Your Ref 2025/91184
Our Ref CRTR-PLAN-2026-46929
Friday 19 June 2026

Proposal: REVISED AND ADDITIONAL INFORMATION RECEIVED: Erection of two storey industrial unit (Use Class E(g)(iii)), with associated car park, service area and other associated works

Location: Land off Bretton Street, Savile Town, Dewsbury

Waterway: Dewsbury Arm (Calder & Hebble Navigation)

Drainage Strategy

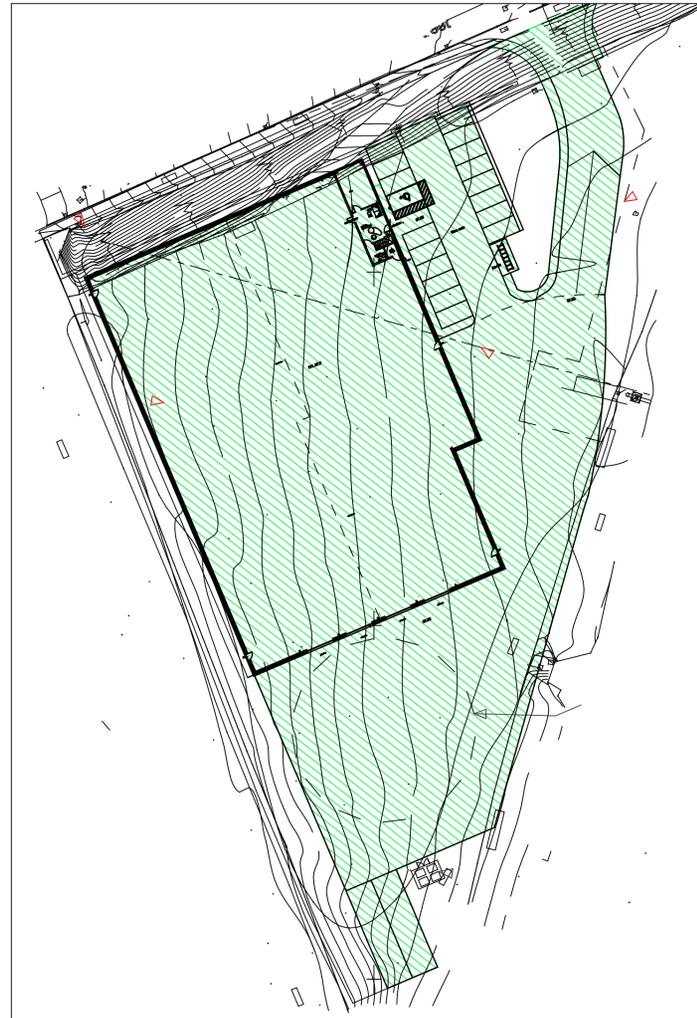
As with the previously submitted details, the submitted drainage strategy shows a proposal to direct both surface and foul water (via package treatment plant) runoff to the canal.

We do request that full details of any Package Treatment Plant should be provided prior to its installation, so that the impact of the foul water connection shown on the canal can be fully assessed. **Details could be reserved through the use of appropriately worded condition(s).**

The Trust's consent as landowner would be required for the runoff shown, even if the proposals seek to utilise any existing outfall. **The Trust has not as yet been contacted by the applicant to confirm that this consent would be forthcoming. The Trust is not a land drainage authority, and our consent cannot be guaranteed** For more details, our Utilities Section can be contacted by email at utilitiesenquiry@canalrivertrust.org.uk or phone on 07483351479. For more information, the applicant may wish to view the leaflet attached below:

NB. We wish to highlight that correspondence internally with our Utilities Section highlights that a foul water connection to the canal from the package treatment plant may be unlikely to gain consent from the Trust in our position as landowner (notwithstanding any planning consent). As a result, the applicant may find it prudent to amend this detail prior to the scheme being given planning consent to avoid delay in any implementation of the scheme. Should they wish to discuss this with the Trust further, our Utilities Section should be contacted by them via the details listed above.
